2021 Financial Assurance Estimate Form
(with pre-plat construction)

PROJECT INFORMATION		
Latigo Trails Fil 10	9/17/2021	SF-XX-XXX
Project Name	Date	PCD File No.

**G1 POND OUTFALL**

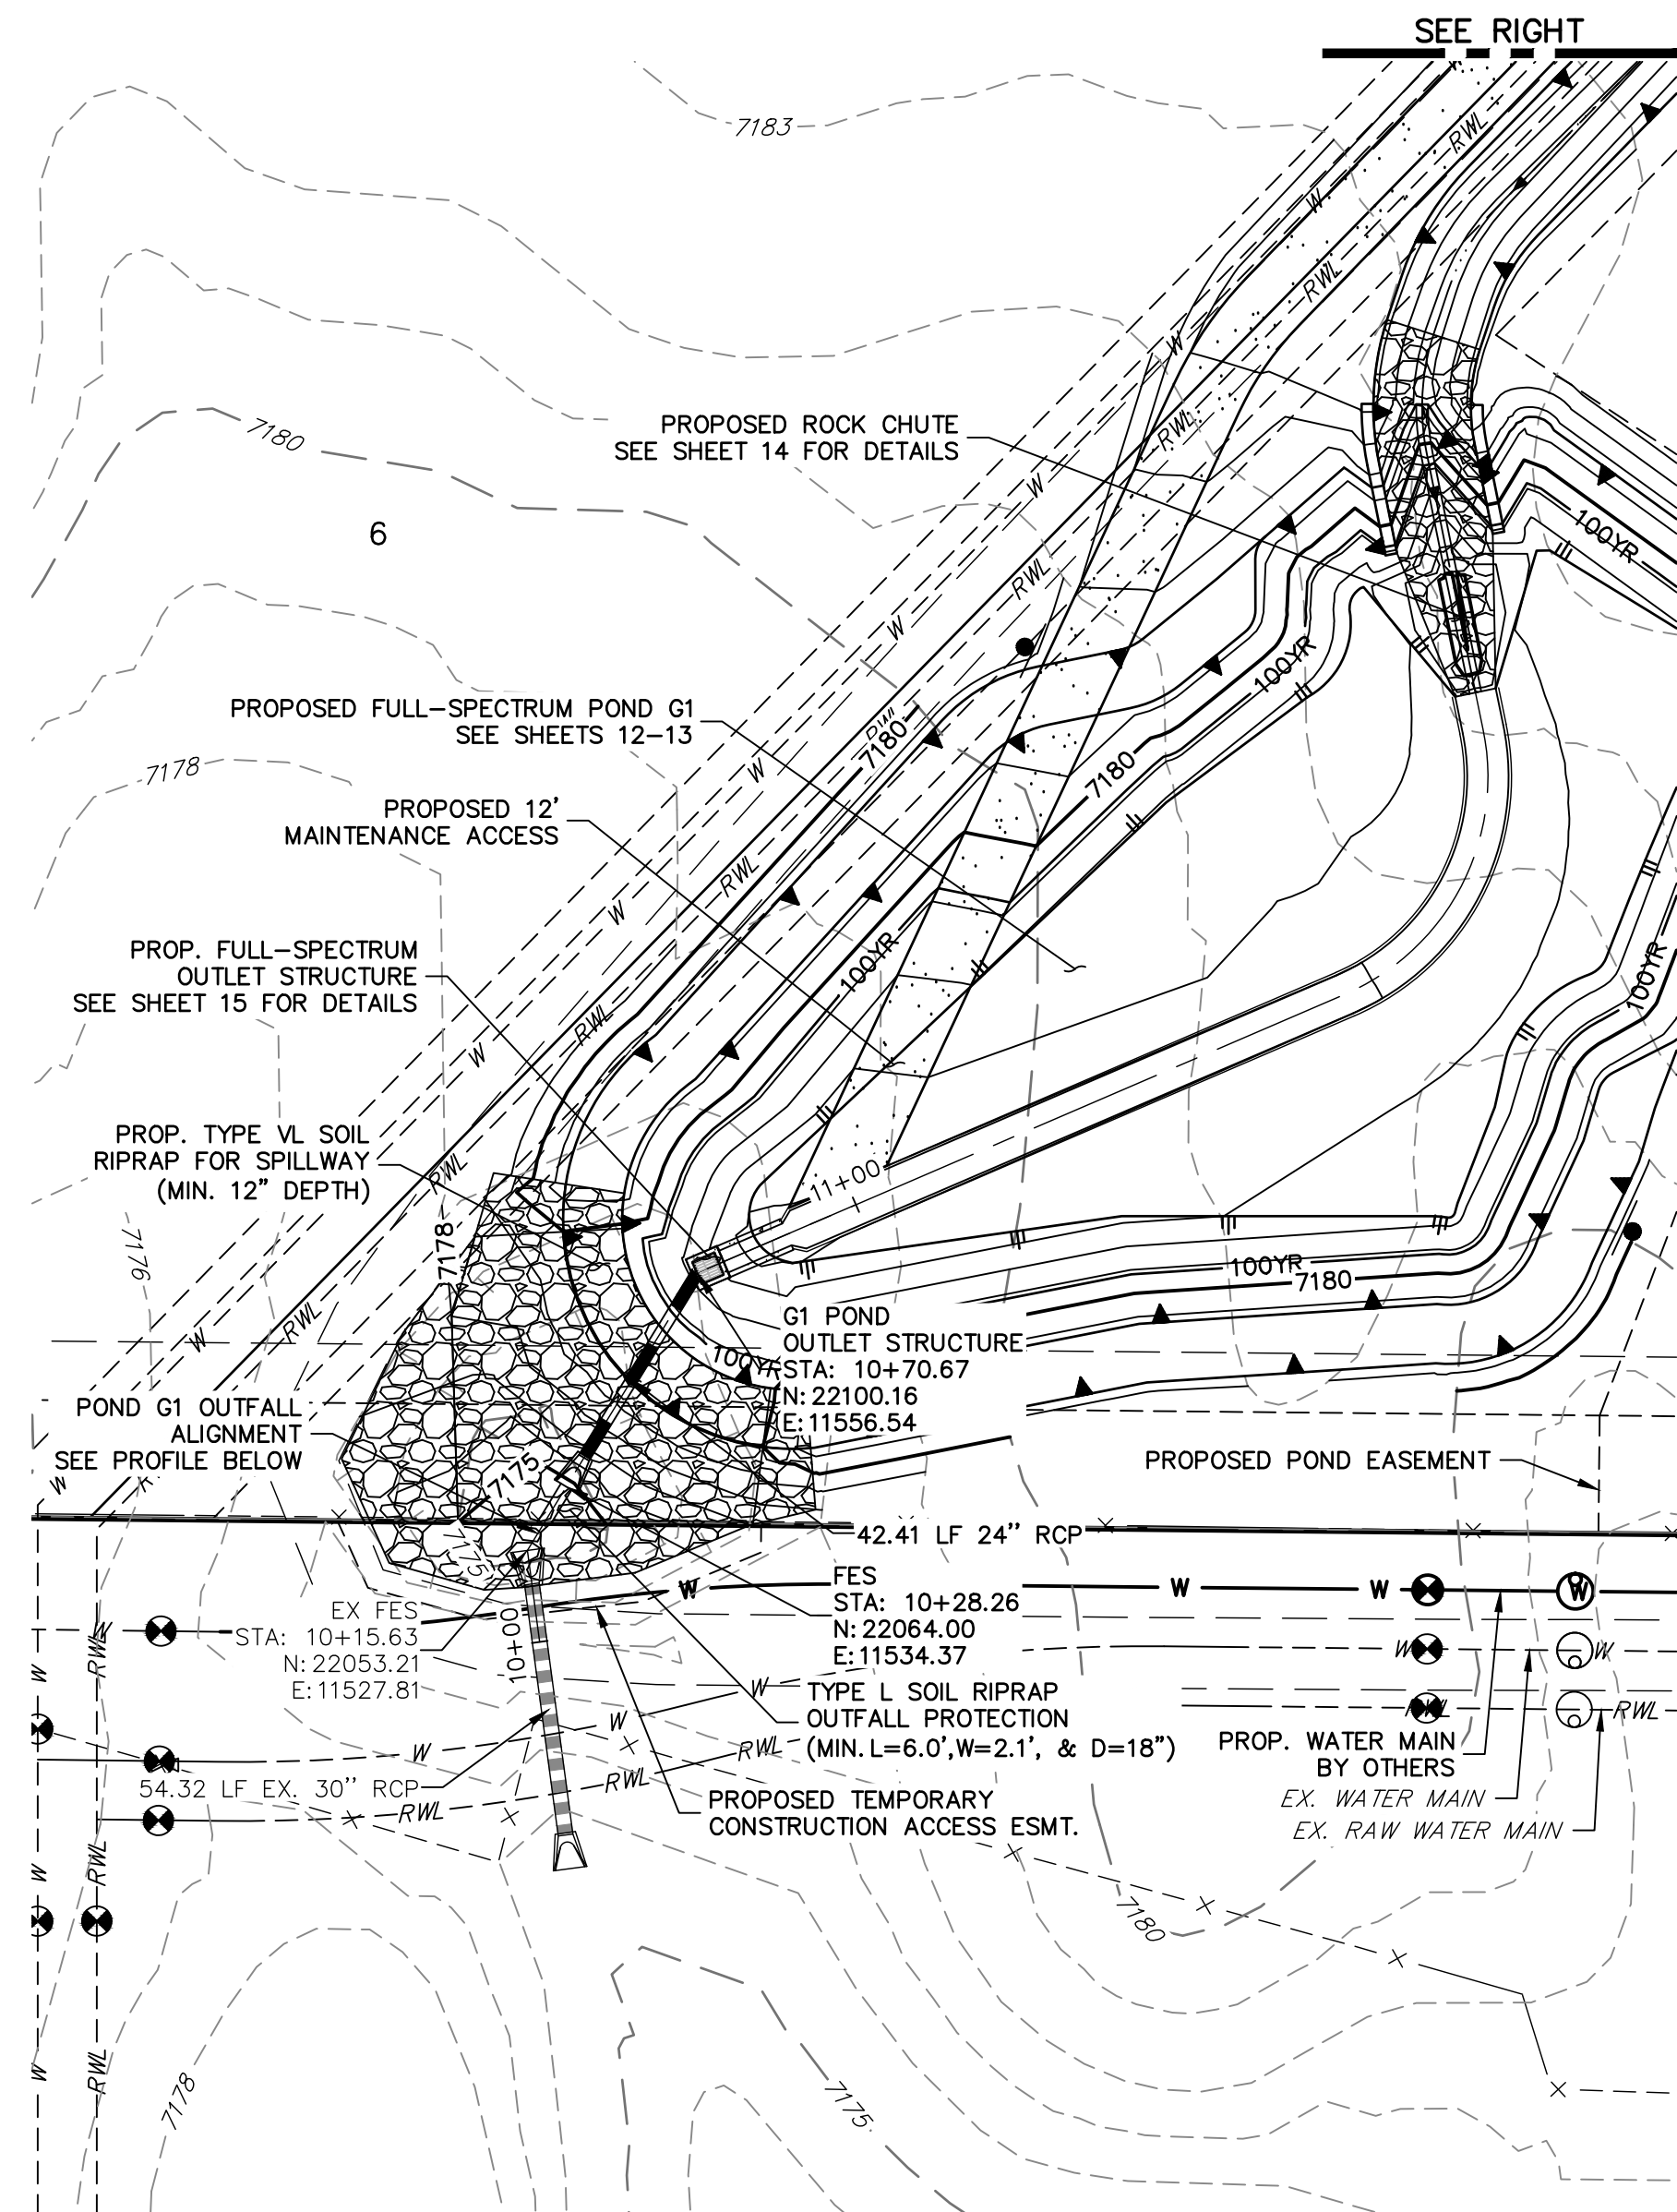
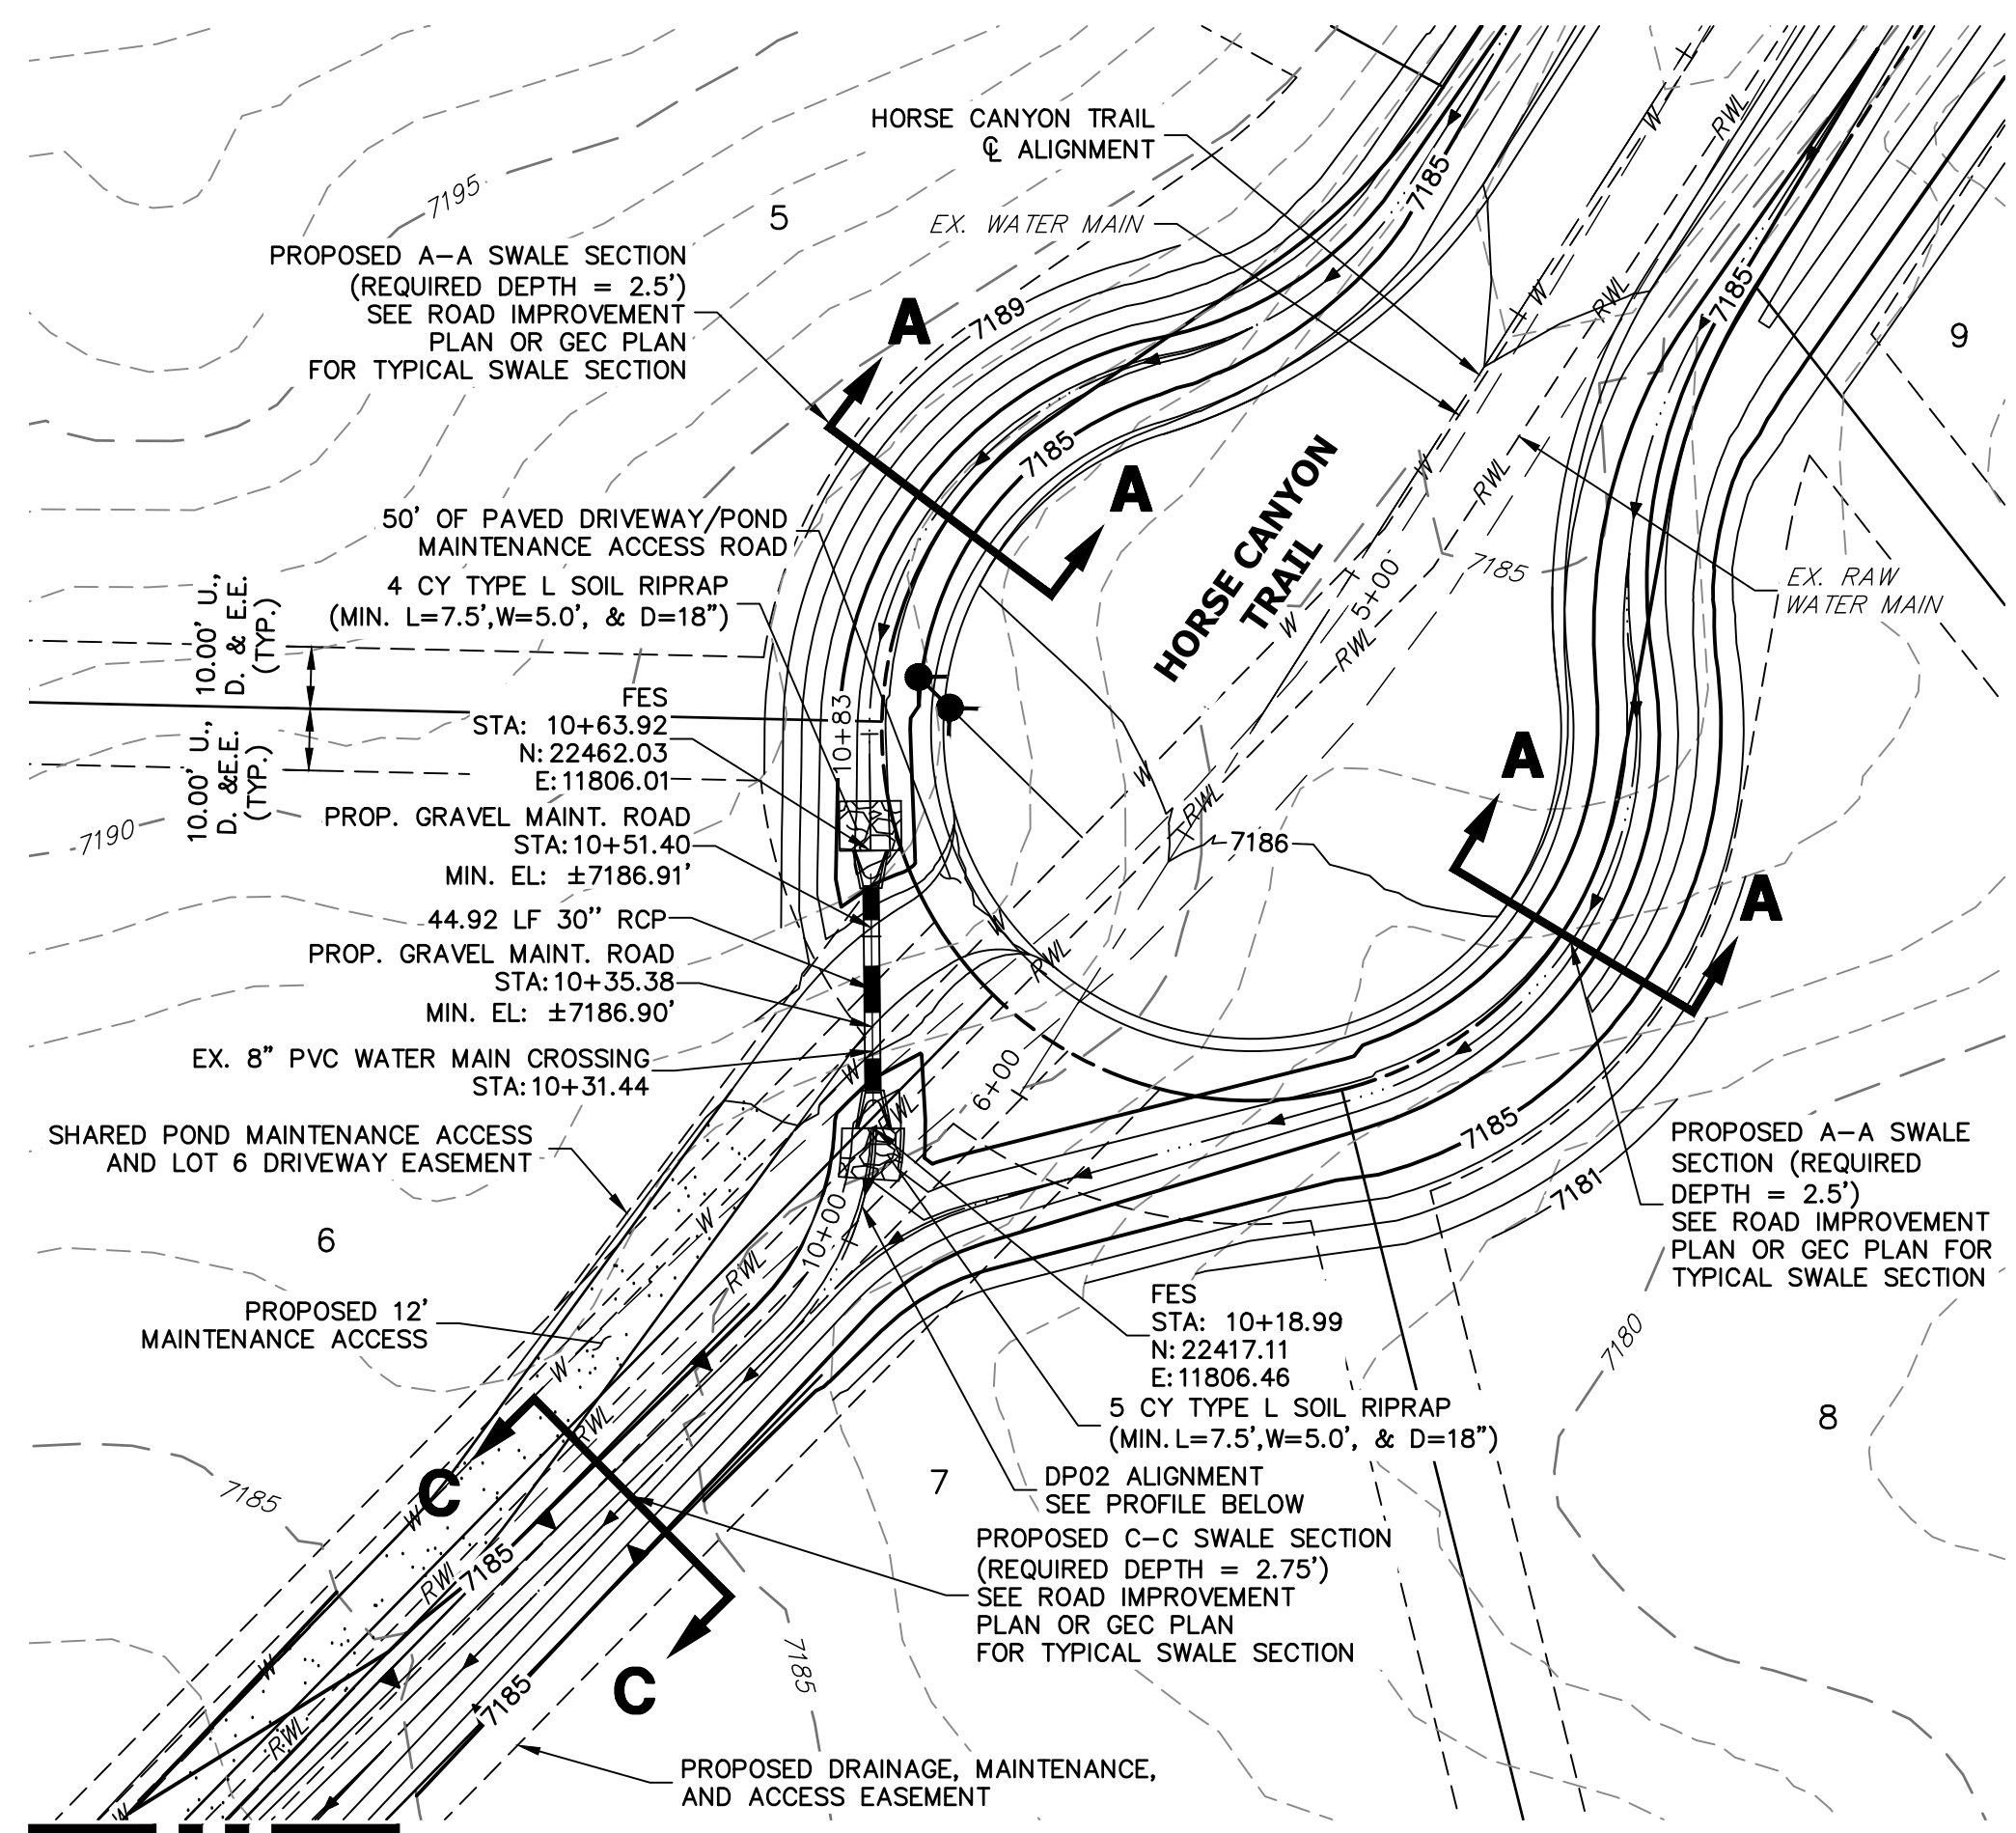
Add the manhole for pond G1 outfall.
